# CITY OF ALBUQUERQUE

PLANNING DEPARTMENT – Development Review Services

July 17, 2015

**RE: American Toyota (File: C18D012)**  
**Drainage Report, Engineer's Stamp Date 3-16-15**  
**Grading and Drainage Plan, Engineer's Stamp Date 3-27-15**

PROPOSED ELEVATIONS (SYSTEM #4)

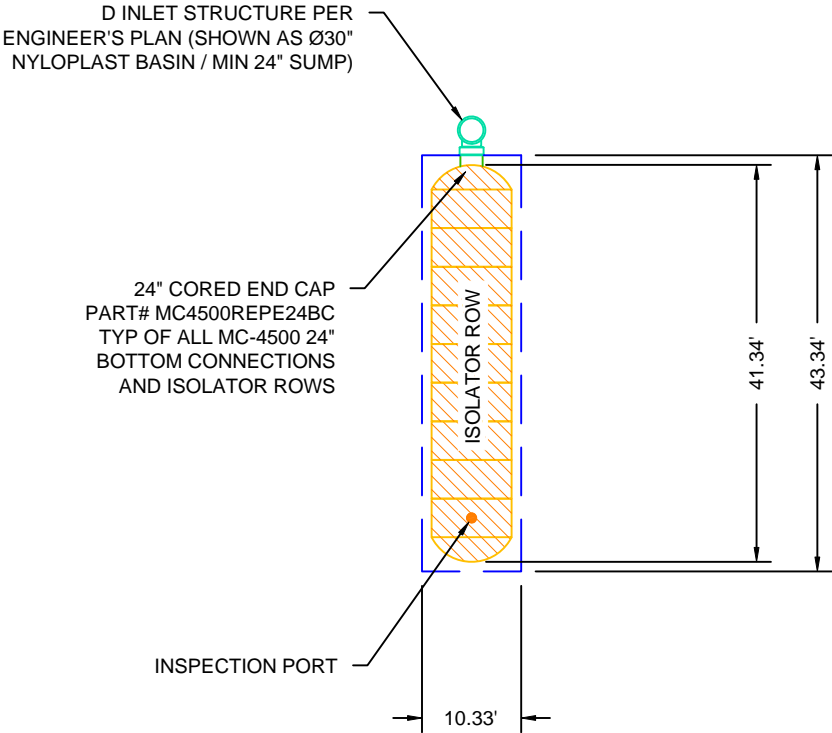
9. **StormTech System #4.** Similar to System #6, the inlet is to fill and overflow to existing inlets. Please provide this detail in section. Also, show that the inlets can capture the peak flow. How will the first inlet capture the first flush without it bypassing to the existing inlets?

PROPOSED ELEVATIONS (SYSTEM #5)

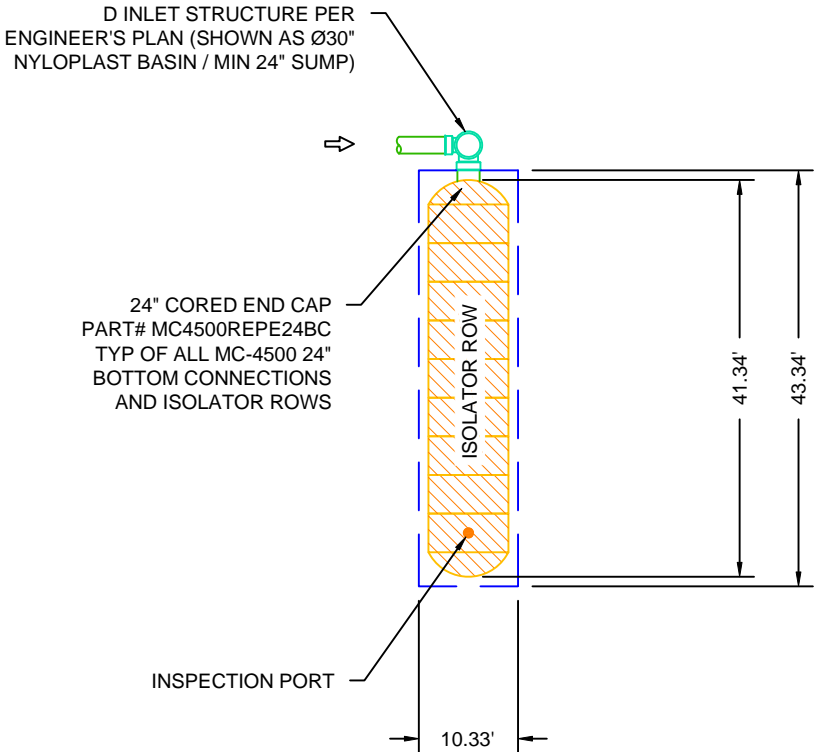
7. **StormTech System #5.** First flush reqd vol. is 1662CF. In order to capture the max capacity, the inverts at the Inlet must be higher than the elevation of the required capacity (refer to StormTech's calcs. ) At a capacity of the 1628CF, the elevation is 5208.35. If the inverts are higher than this you will not have enough cover. Do you need to lower the Storm Tech System? Show connection details of this system.

PROPOSED LAYOUT (SYSTEM #6)

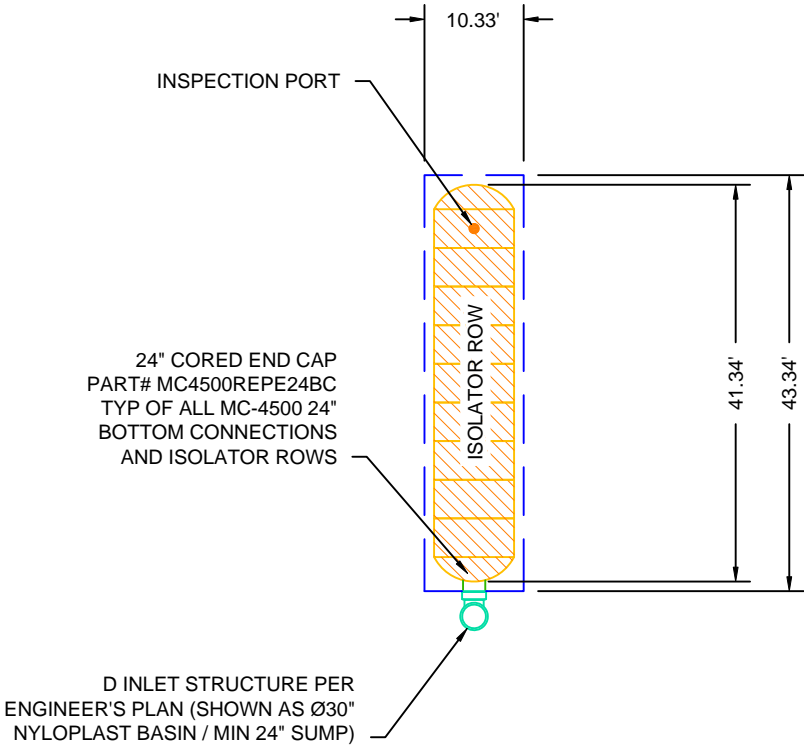
6. **StormTech System #6.** The invert out to the existing is much too low to allow the required first flush. Per our conversation, you intend to put 2 inlets so that once the StormTech system fills, it will overflow to the 2<sup>nd</sup> inlet. Please provide this detail in section and also show the 2<sup>nd</sup> inlet on the plan. Also, show that the inlets can capture the peak flow. How will the first inlet capture the first flush without it bypassing to the 2<sup>nd</sup> inlet?

MC-SERIES END CAP INSERTION DETAIL

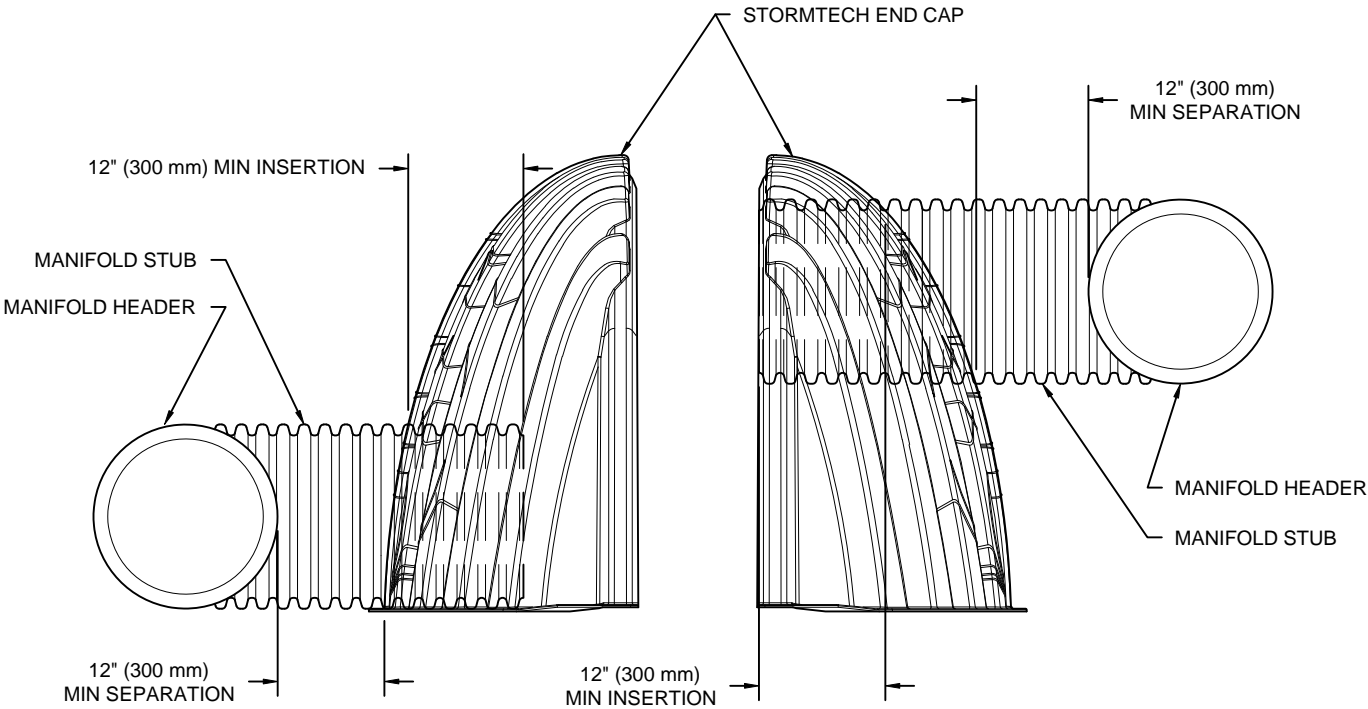
4. StormTech construction documents state that the engineer is to size the manifold. Call out manifold size on your details.
5. Show D inlets can capture the peak flow (or 7cfs) at System #4 and #6. Is it in a sump? Is there curb there to develop a head?

ENGINEER'S SEAL 	AMERICAN TOYOTA		DRAWN BY WCWJ
	GRADING AND DRAINAGE PLAN		DATE 3-27-15
 1606 CENTRAL AVENUE SE SUITE 201 ALBUQUERQUE, NM 87106 (505) 872-0999	SHEET #		21403-LAYOUT-1-25-14
	JOB #		21403

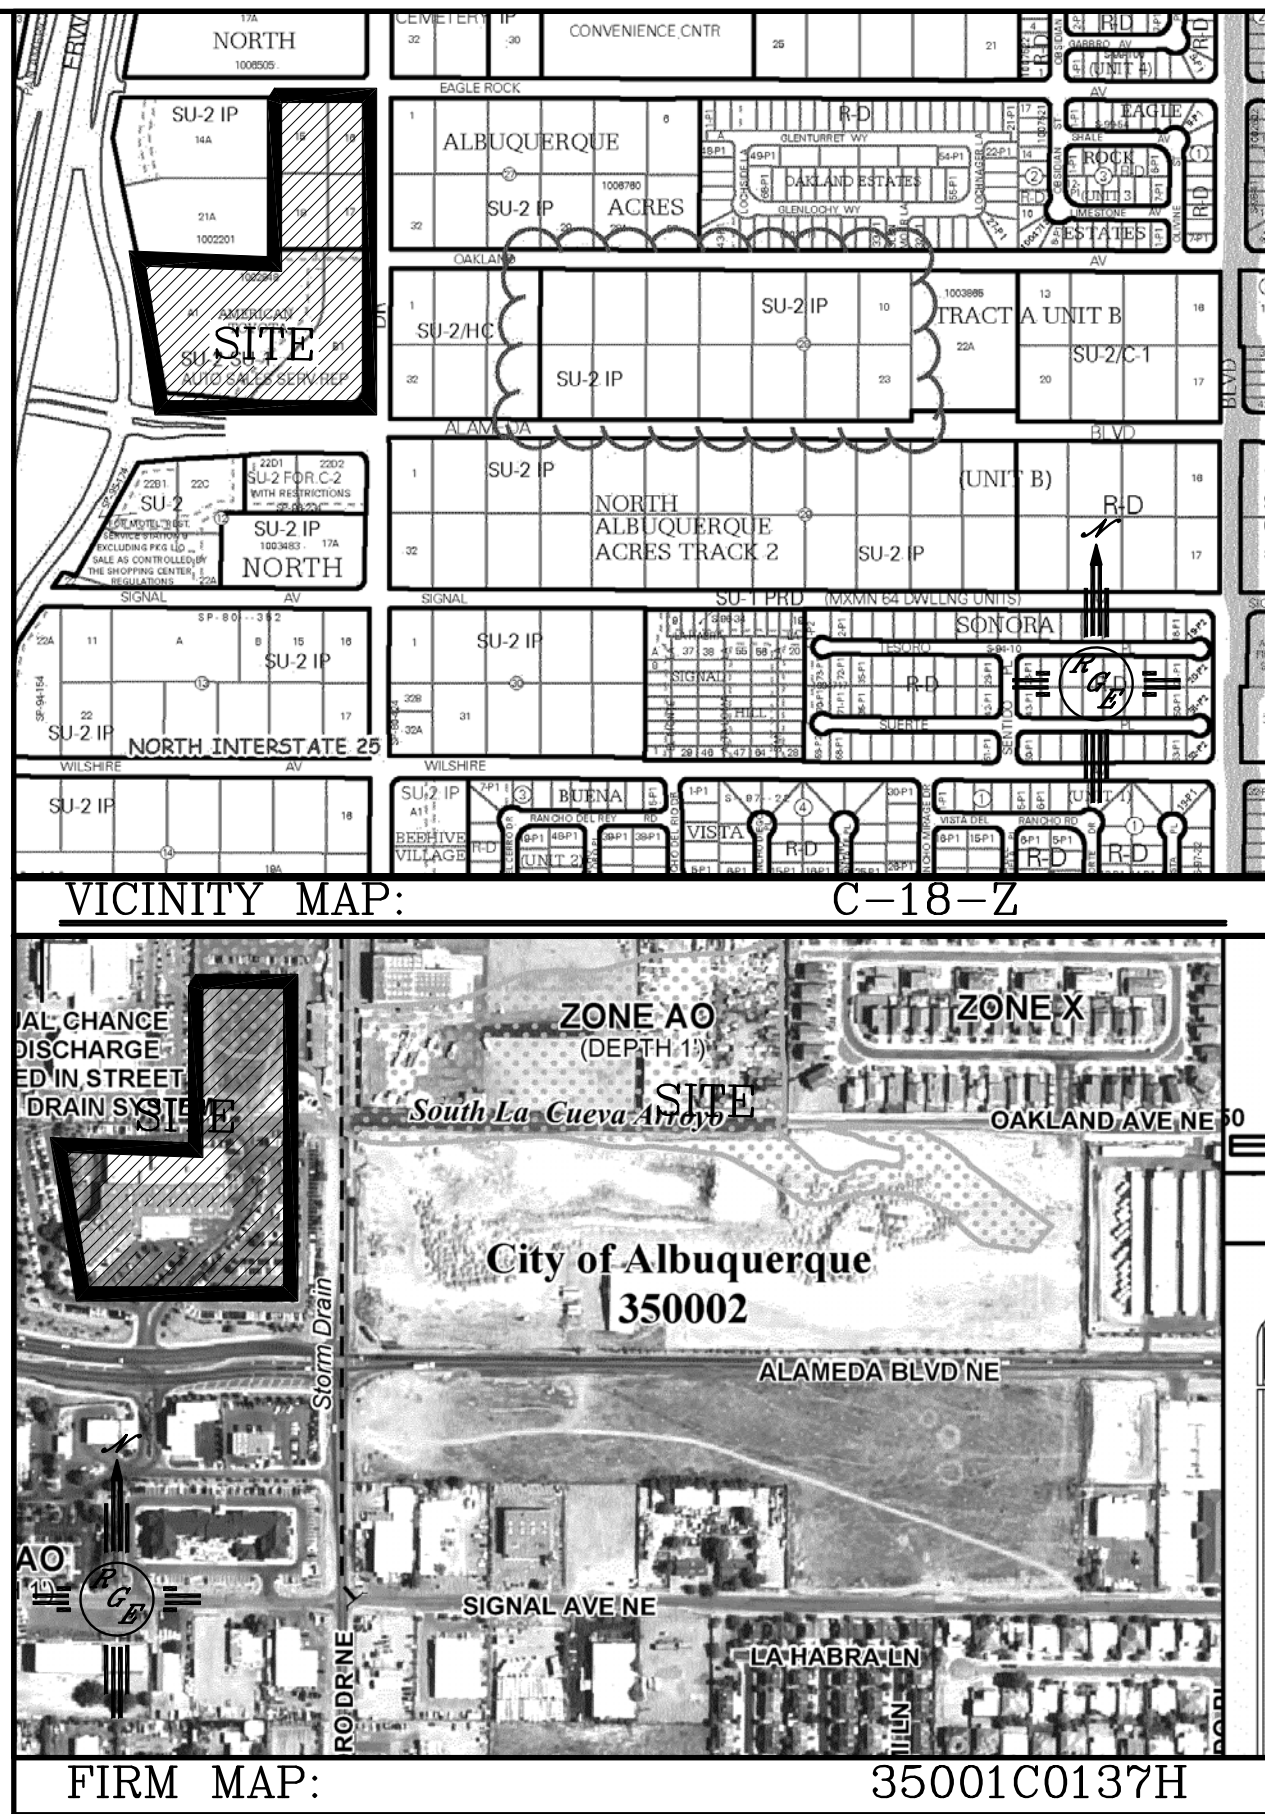
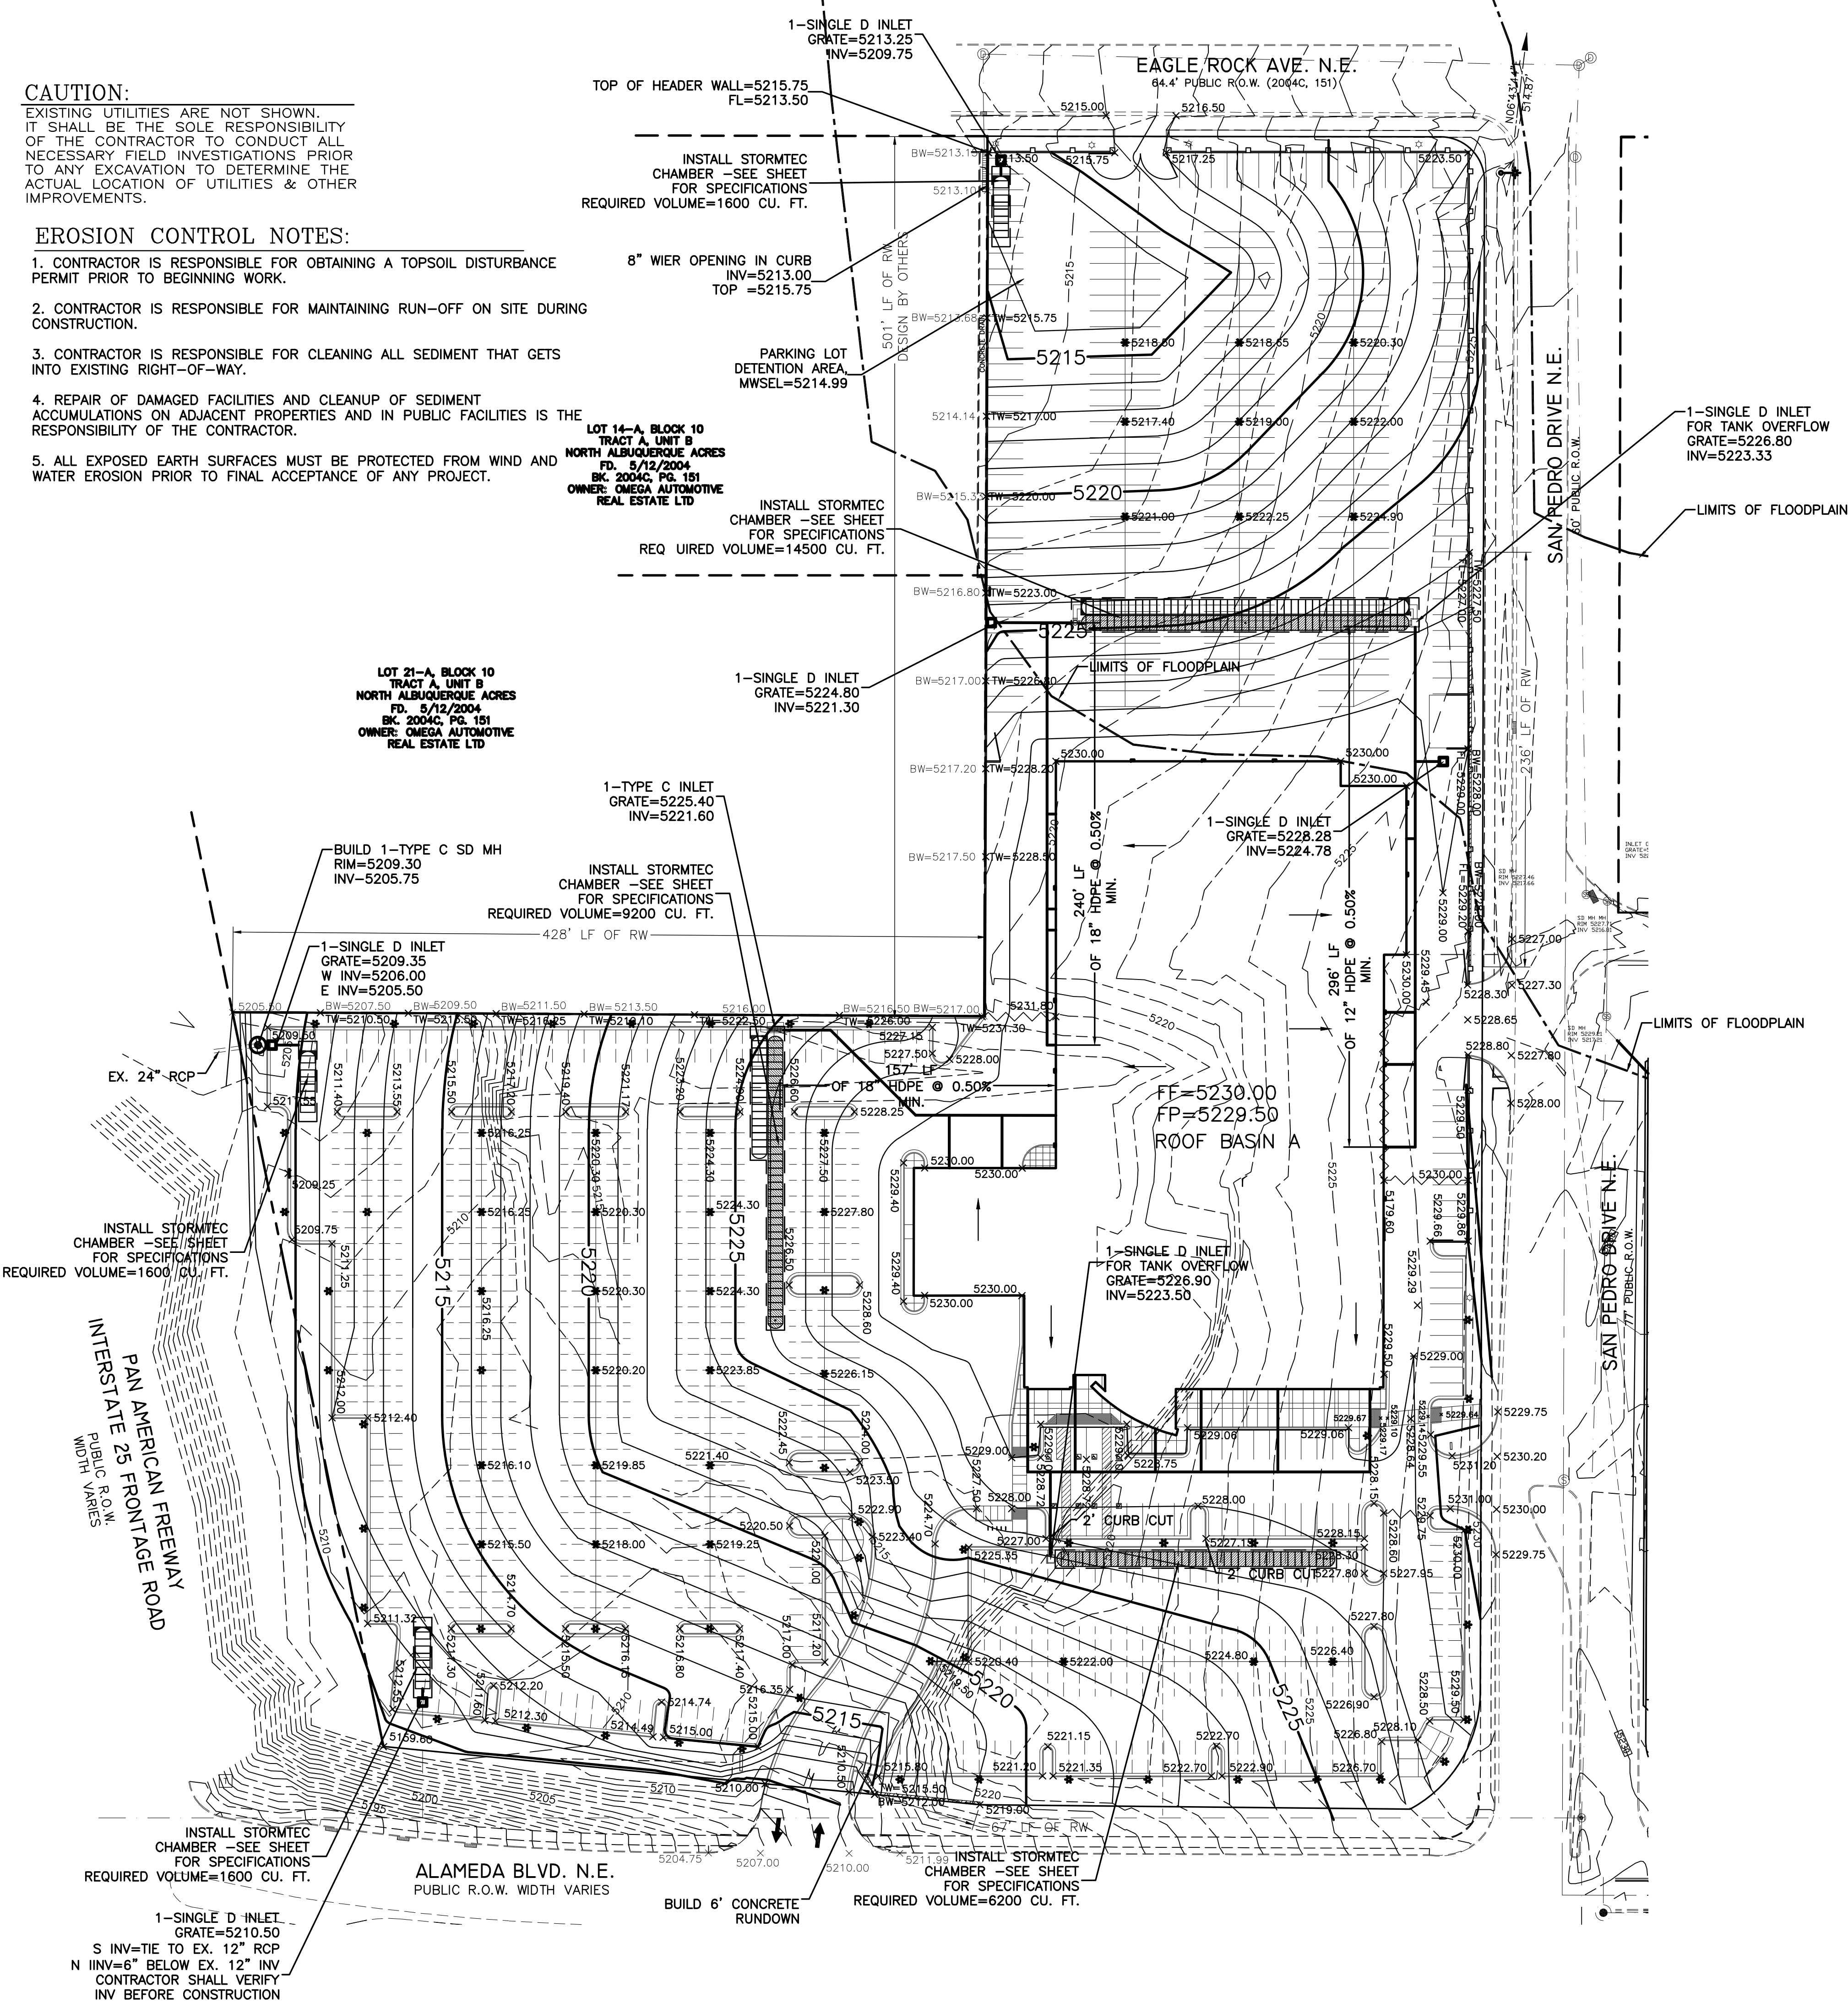
2. Label the pipe size and type for all underground Storm drains connecting to the StormTech systems. Show connection details to inlets or manholes.
3. Label each StormTech system on the plan with that shown in the report calculations and StormTech's construction Drawings, ie. System 3
